**THE NORTHAMPTON GATEWAY RAIL FREIGHT INTERCHANGE ORDER 201X**

**NORTHAMPTONSHIRE COUNTY COUNCIL'S RESPONSES TO ExA QUESTIONS IN TABLE TO ISH3 AGENDA**

SECTION S - S': A508 - Rookery Lane / Ashton Road Junction Improvement Scale: H 1:100,V 1:100. Datum: 92.500m

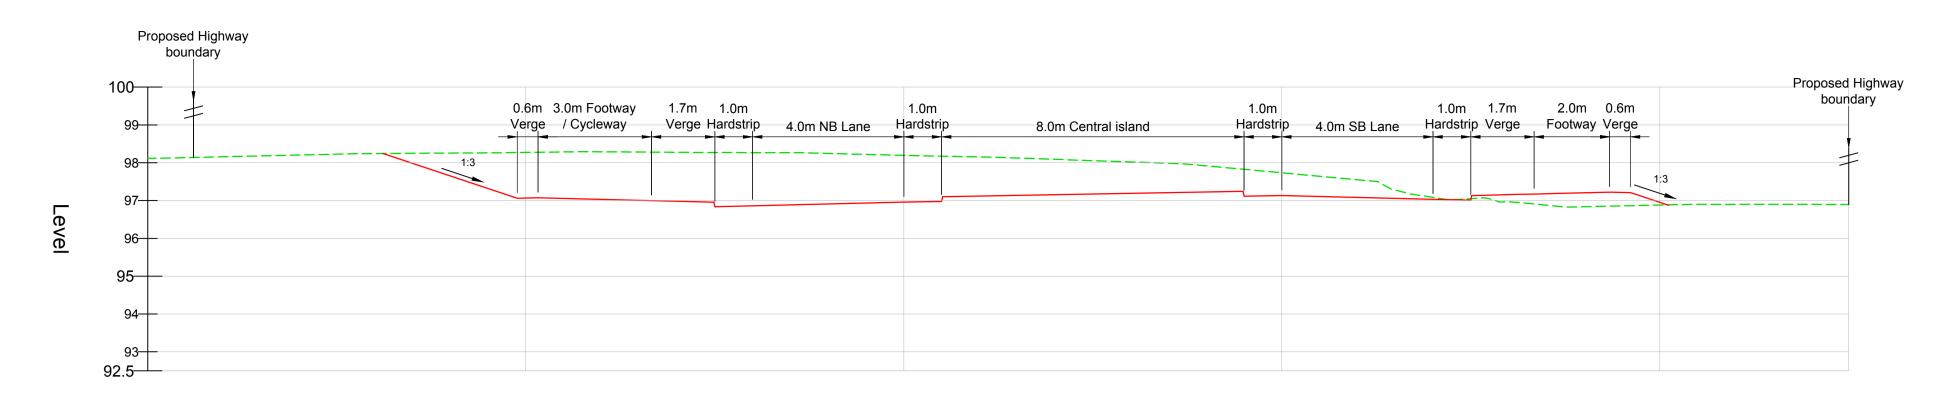
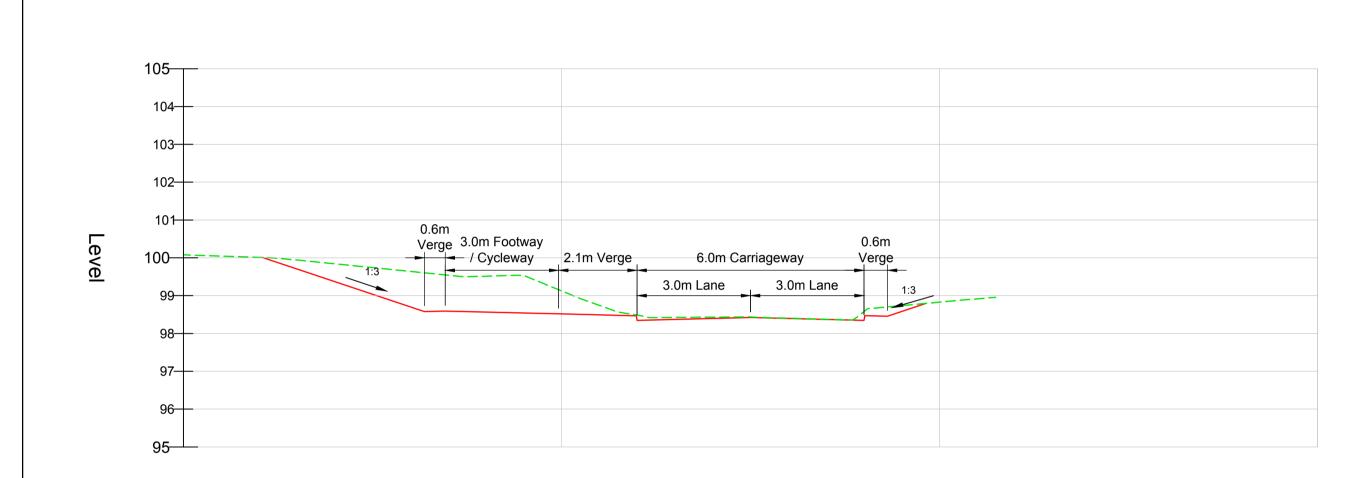
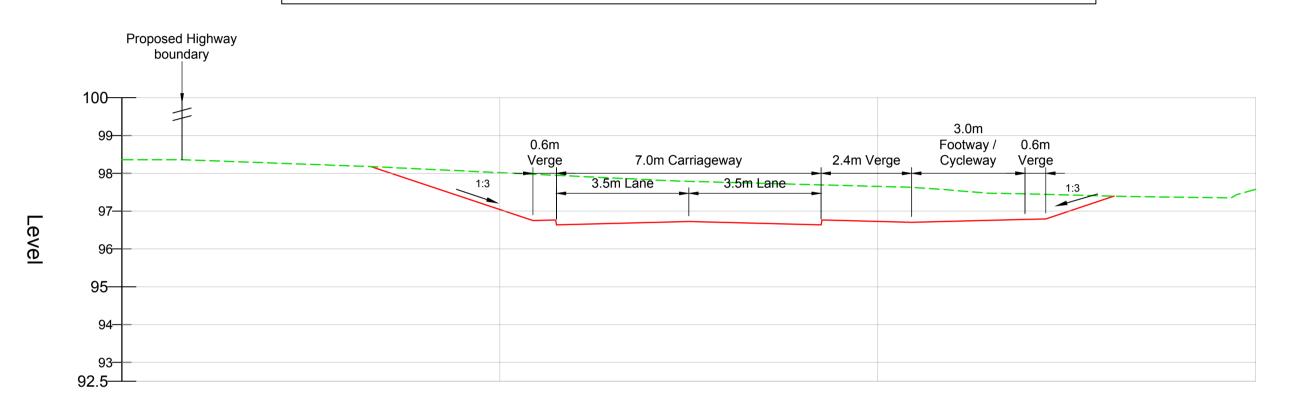
6	NCC, Messrs AW, W & R Irlam	Art 10 and Sch 4 Column 2	A508 highway The three stoppings up at the Rookery Lane/ Ashton Road/ A506 jn (x, xii and xiv on Doc 2.3E [APP-025])	<p>The Relevant Representation from Berrys on behalf of AW, W &amp; R Irlam says this:</p> <p>“The current layout [of the junction] facilitates tractors with cultivators, long combine harvester headers, etc., to swiftly across [sic] the junction without any road furniture/ structures impeding the route. The revised layout includes a central island which will impede or possibly even prevent agricultural vehicles swiftly and safely crossing. ...</p> <p>The conclusion is that if the DCO is granted then it must incorporate a further revision to the road layout at this junction to ensure the on-going safety of large vehicles including agricultural machinery. Any change to junction layout must also minimise land taken from agricultural production.”</p> <p>Does the Applicant propose any redesign of the junction? If so, how?</p> <p>Does this representation go to the question of whether the stopping up can be approved at all, because of the design of the alternative? Or does it go to the question of</p>	<p>The question about agricultural movements across the junction has been raised and it is incumbent upon the road user to ensure they can traverse the highway appropriately and safely. There would also be, as part of the detailed design of the junction, a Safety Audit process in accordance with DMRB standard GG119 and the use of the junction by agricultural vehicles of this nature can be brought to the attention of the auditors so that consideration can be made at that point.</p>
